2 Storey side extension & single storey rear extension
9 Brook Lane Ferring

Thank you for your internet representation made on 16th October 2014 which has been recorded as **'an objection'** with the comments as follows:

PROPOSED ELEVATIONS 1:50

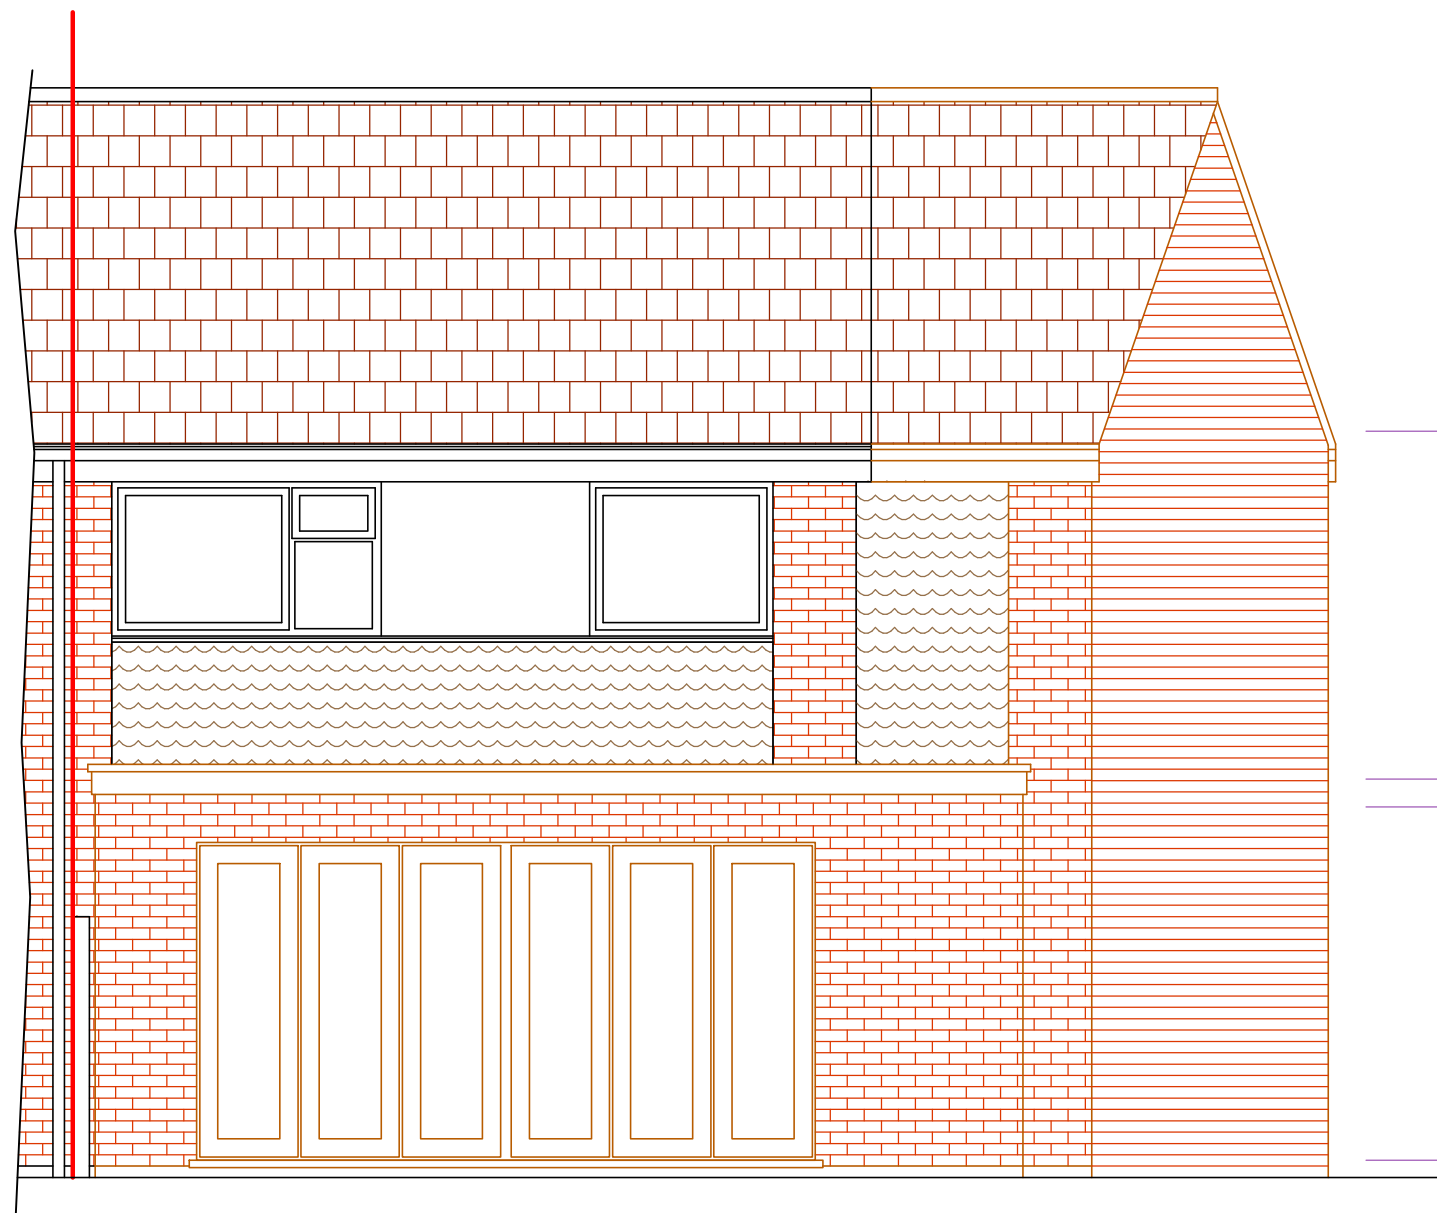
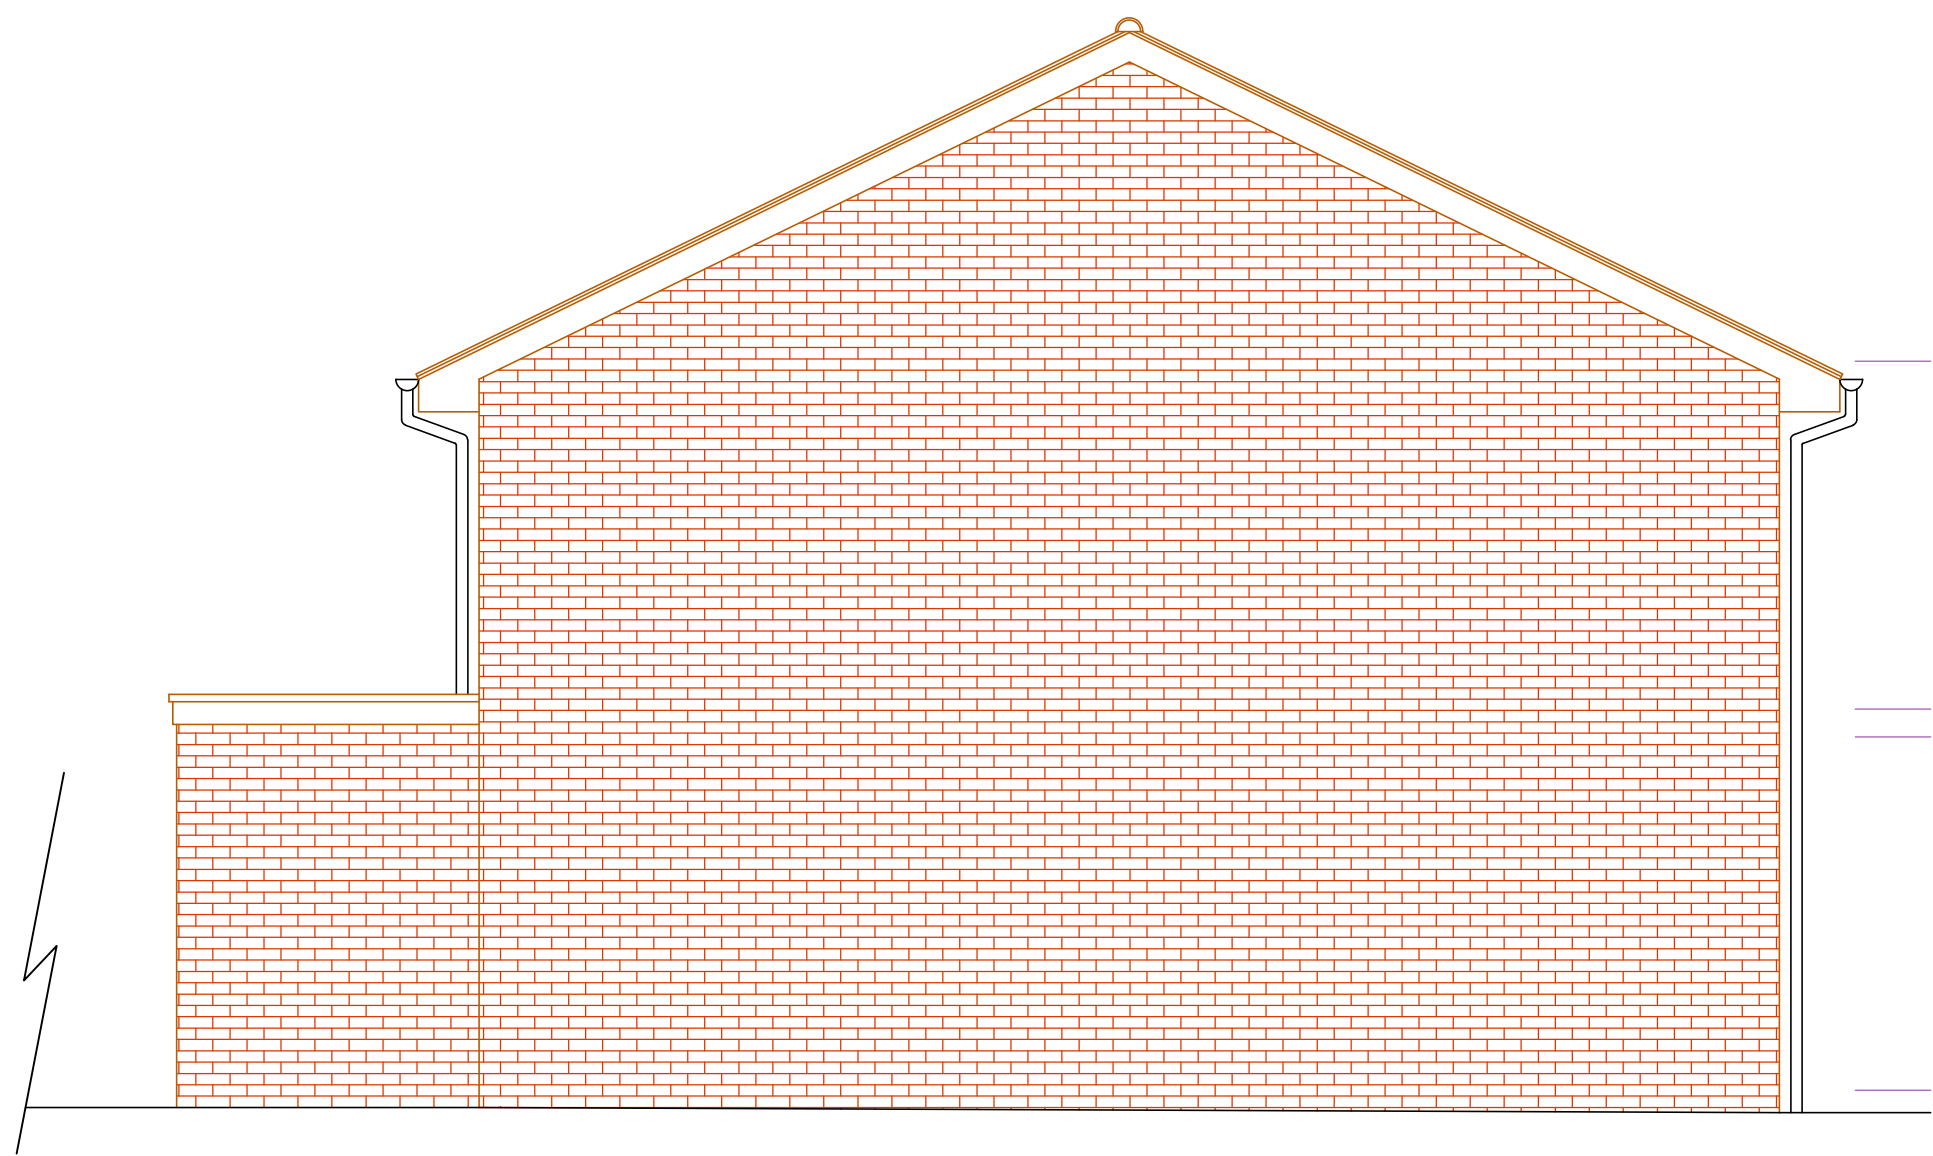
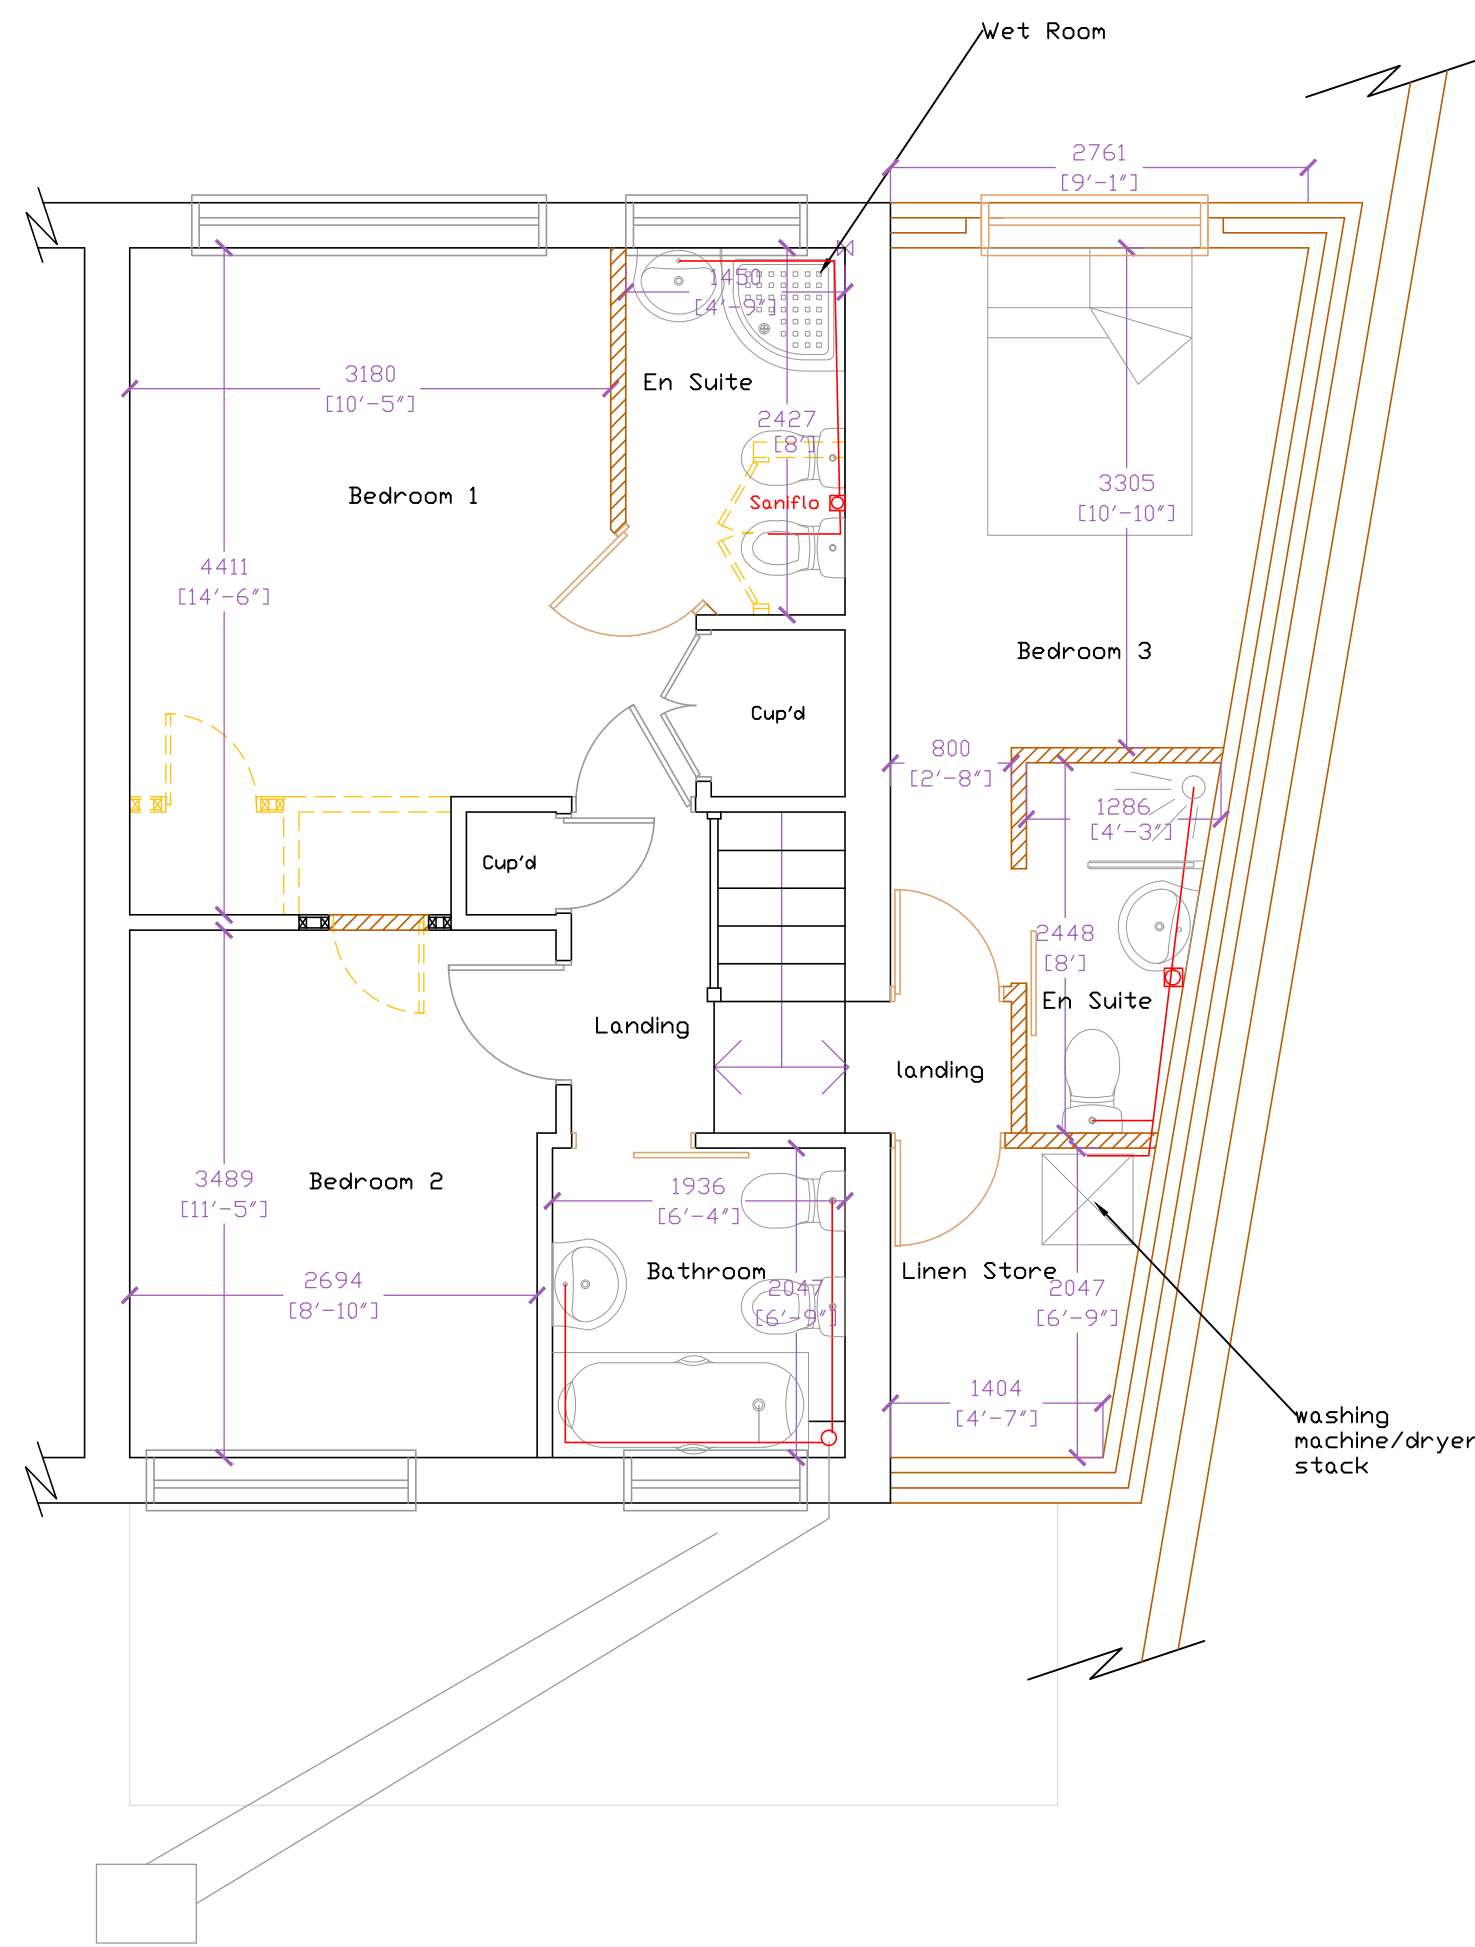
OBJECTION 1)- is to the new overall look of the block of 5 terraced houses. Adding what looks like another half a house on the end is totally out of keeping & character with the existing look to the Brook Lane set of houses, that match the block of 5 set of terraced houses in Barbary Lane, that were built at the same time as part of the same set. I feel this new look would de-value my property should I ever wish to sell. Why can't the extension be a single story extension to the side in keeping with the existing frontage.

PROPOSED FLOOR PLANS 1:50

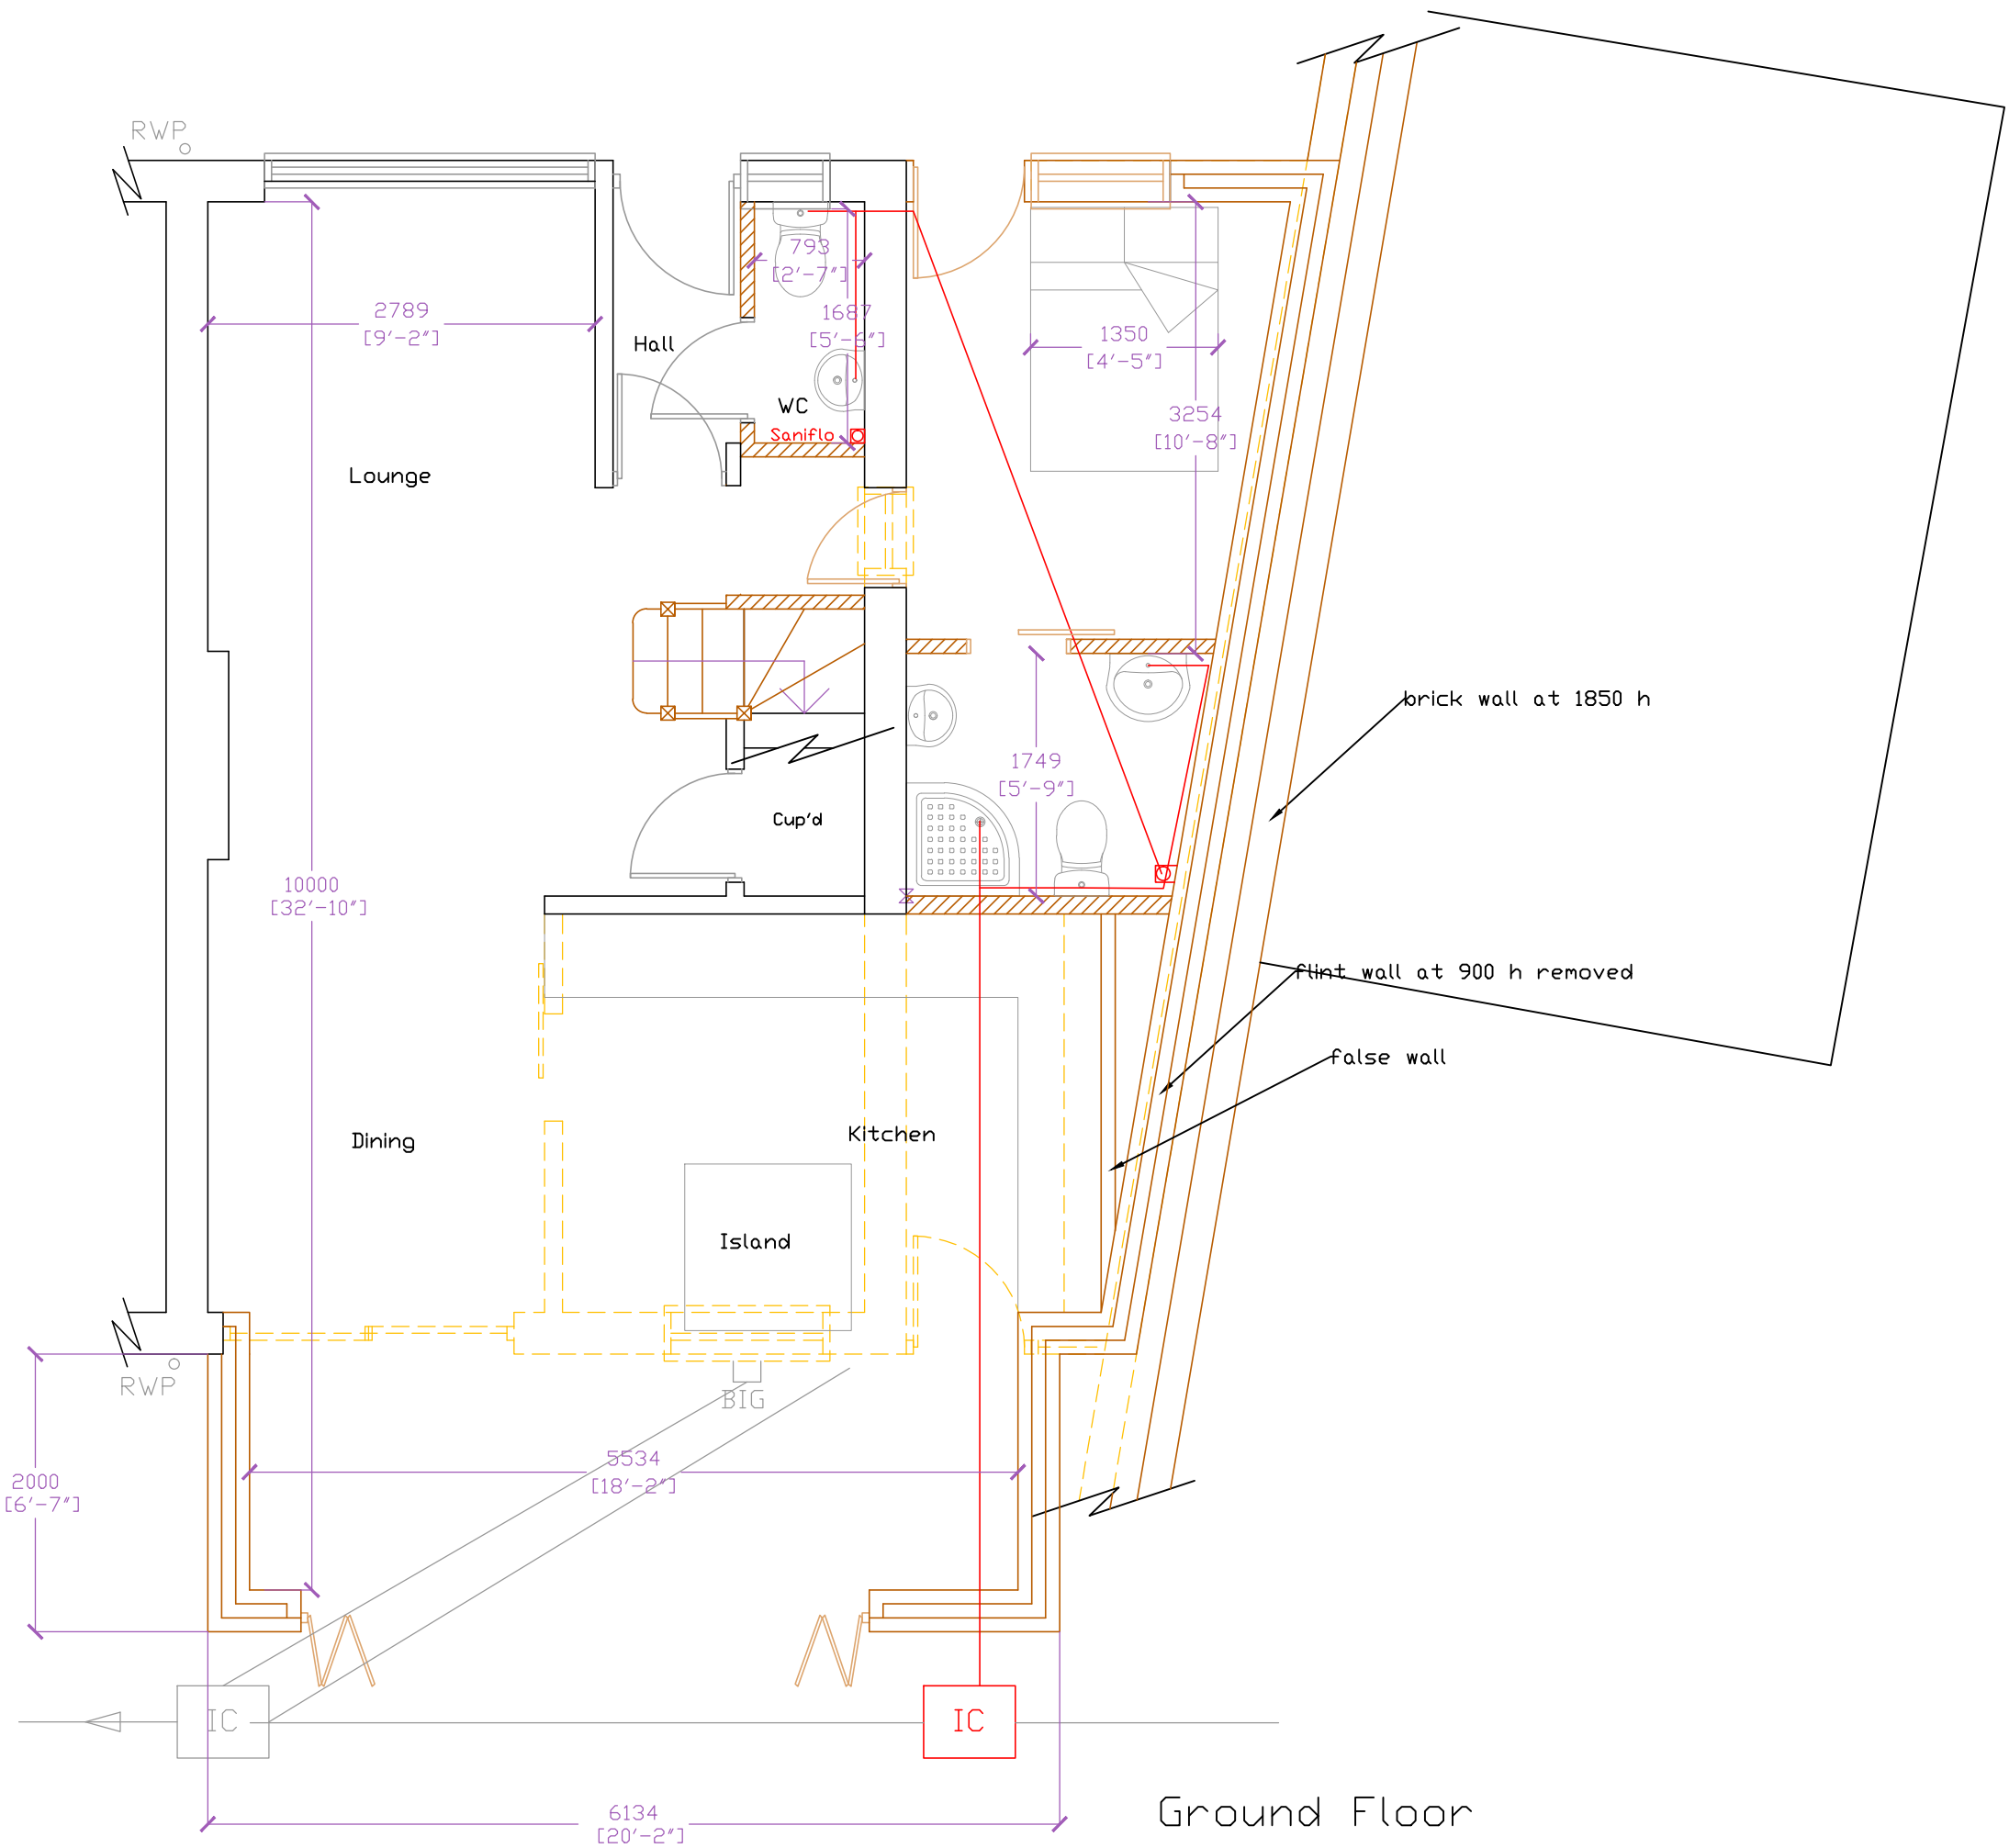
OBJECTION 2)- considerable concerns about parking in this narrow Lane, which already has very limited on road parking & is already full of cars from the employees at Benton Weatherstone stone merchants, next door to the plot concerned, Mon -Sat 8am-5.30pm. No 9 Brook Lane only has one off road parking space & Garage for this existing 2

bedroom house, by increasing the property size to what is in effect, a 4 bedroom house. if the buyer/renter has more than 2 cars where will they be parked ? OBJECTION 3)- The existing house has NO downpipes to either the front or the back, to carry rain water away, this is channelled down towards the other 4 houses at 3 points. I notice on the proposed plans to the new side elevation they show downpipes to carry rainwater away, yet on the proposed plans for the new rear & front proposed elevations ,they show NO downpipes to carry the extra rainwater away. Which one is it meant to be ? If NO new downpipes are to be fitted on the new end extension how is our existing guttering meant to cope with all the extra water it will have to carry away. Other queries- (Chancel liability) This building is located within the historical boundary of a tithe district within a parish, based on historical parish boundary data, does permission have to be sought form the said parish ? Also if these plans were to go ahead I have grave concerns as to where all the excavation & work persons vehicles will park whilst the work is being carried out. There is no rear entry access to the proposed site or parking, there is only a small passage walk way that serves the back of the terrace block for taking out of bins and access to the garage compound area, where NO parking is permitted.
